Department of Planning and Environment

Our ref: DOC22/251028

Your ref: SSD-15822622

Subject: EHG comments on the Response to Submissions for the Ivanhoe Estate Redevelopment – Stage 2 - SSD-15822622

PL4 THE MEWS

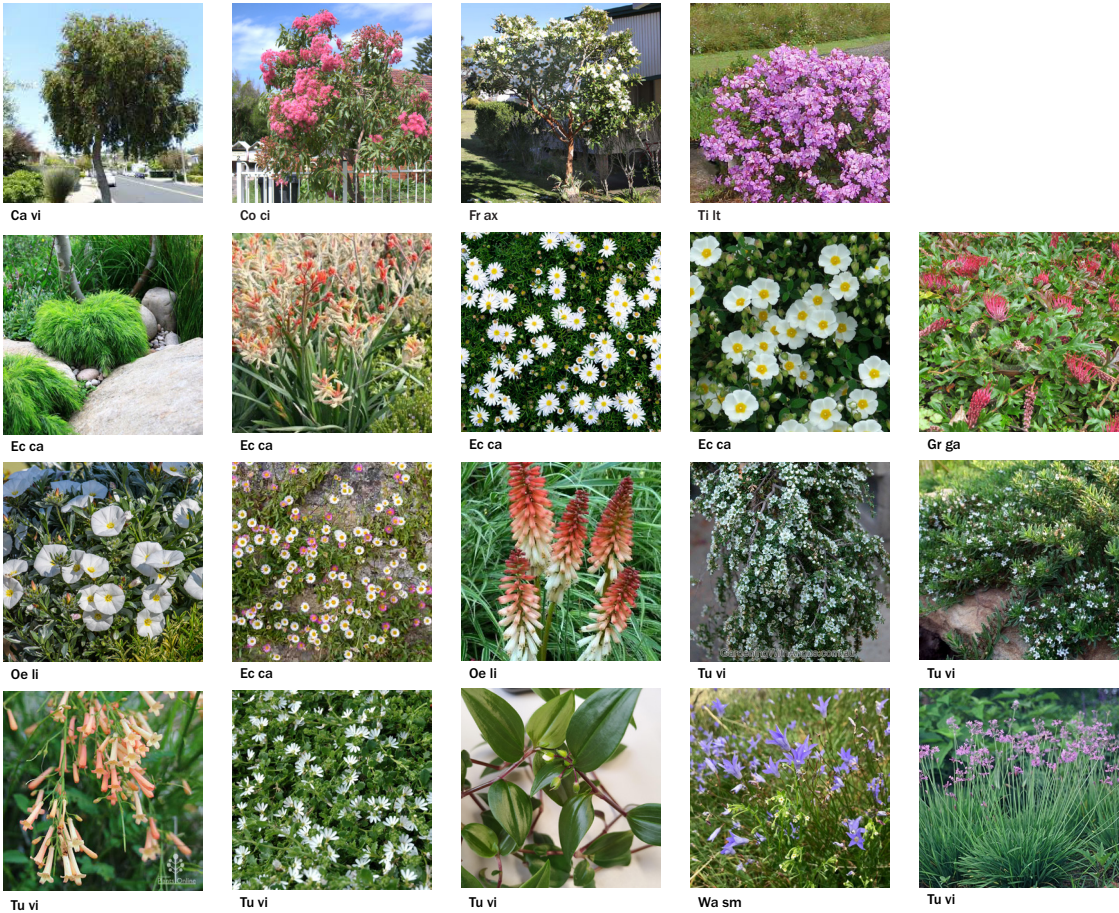
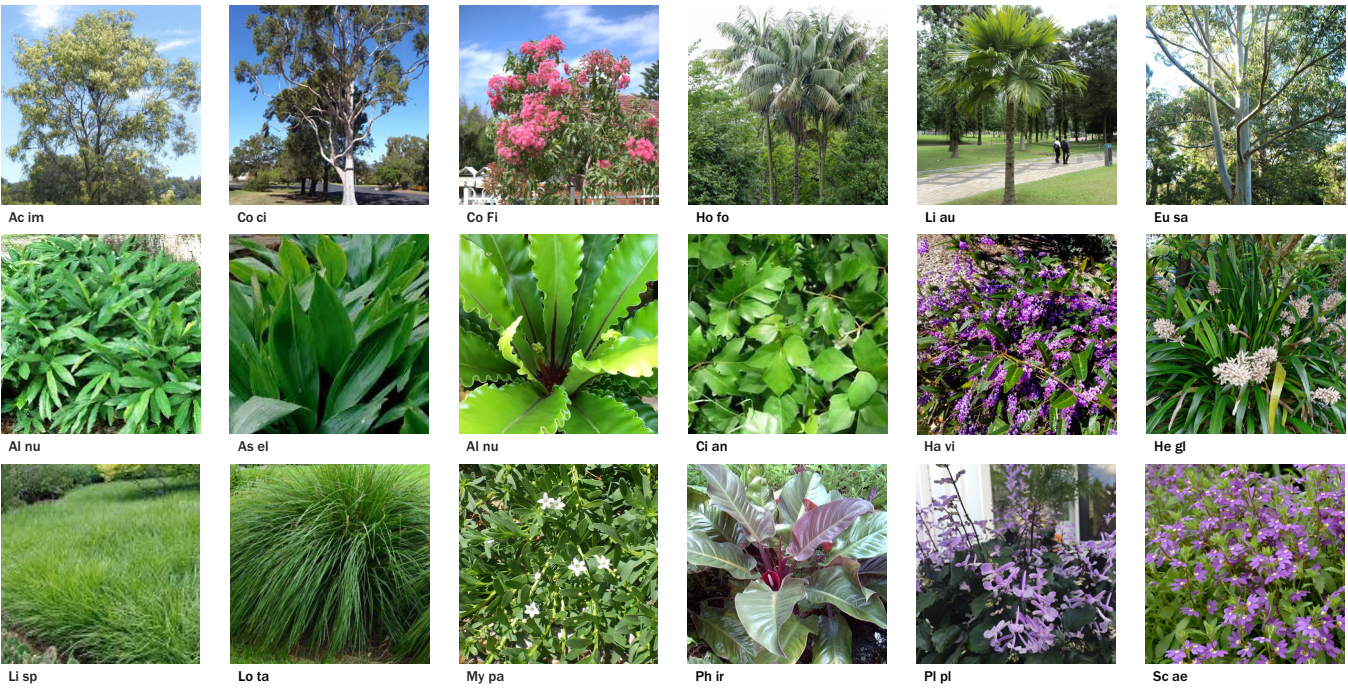
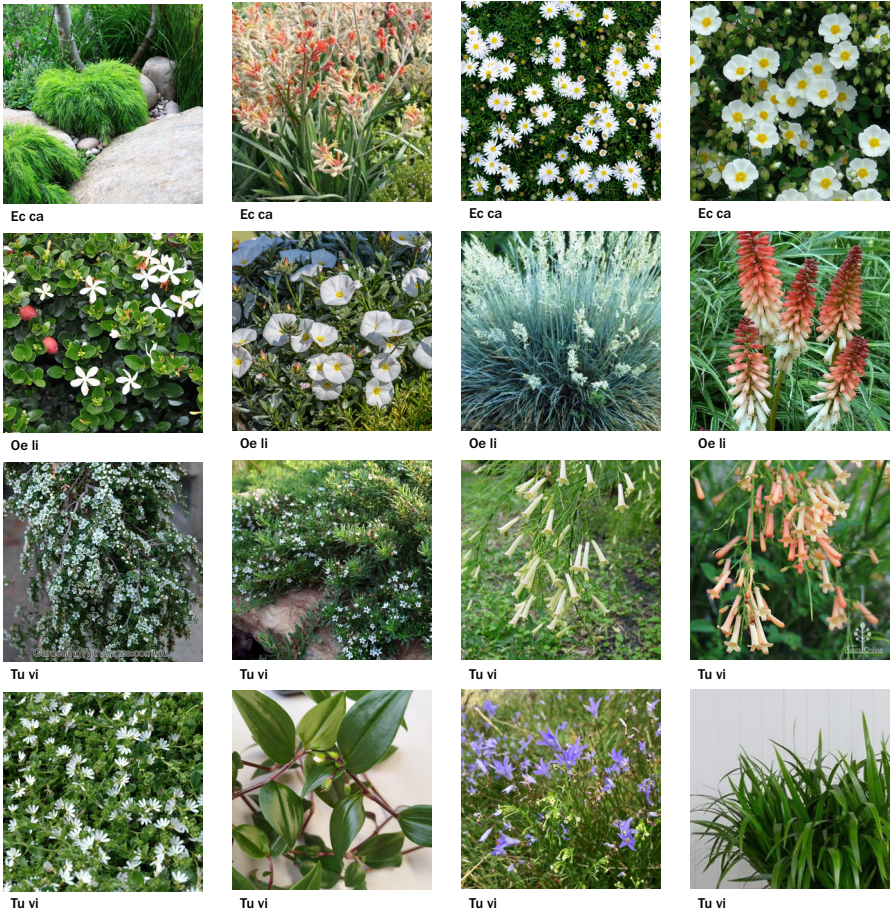
EES previously noted Lemon-scented Gum (*Corymbia citriodora*) is proposed to be used in the Planting Schedules for Block C4 including along Shrimptons Creek. As Lemon-scented Gum is not associated with the native vegetation communities which occur on the site, EES recommended it not be used. In response the RtS states Lemon-scented Gum has been replaced with an alternative species in the revised planting schedule for Block C4 (page 49) but the RtS response does not identify what the replacement species is, or whether it is a native species of local provenance.

As C4 Block adjoins Shrimptons Creek riparian corridor, EES recommended the planting schedule for C4 Block, especially the Shrimptons Creek interface area (the open space between the C4 and the Shrimptons Creek Parkland), the 'Shrimptons Creek Private Open Space' and the 'Neighbourhood Gardens' which adjoin the Shrimptons Creek interface area, consist of local native provenance species and that the Planting Schedules should demonstrate that the plant species consist of local native species. In response the RtS states:

The RtS also states "all planting mixes within publicly accessible open spaces have been adjusted to respond to the comments received and a key has been added to the planting mixes to indicate where the deciduous trees are to be planted within Block C4 and to demonstrate that the plant species consist of local native species" (page 49). While the key shows if the plant species is 'native' this may not mean the plant species consist of local native species from STIF and CESMF. For example, the Planting schedule in Appendix C of Appendix E for PL3 (Shrimptons Creek Private Open Space) includes Kangaroo Paw as 'native' plant but Kangaroo Paw only occurs naturally in the south west of Western Australia. As C4 Block adjoins Shrimptons Creek riparian corridor the Planting Palettes should demonstrate that the plant species are local natives from STIF and CESMF.

The VMP specifies that a "suitably qualified and experienced bush regeneration contractor is required to implement this VMP" (section 1.3). Due to the proximity of the riparian corridor to C4 Block EHG recommends a bush regenerator reviews the proposed planting palettes/schedules for this SSD to ensure the site landscaping/planting uses native species of local provenance and this is included as a condition of consent.
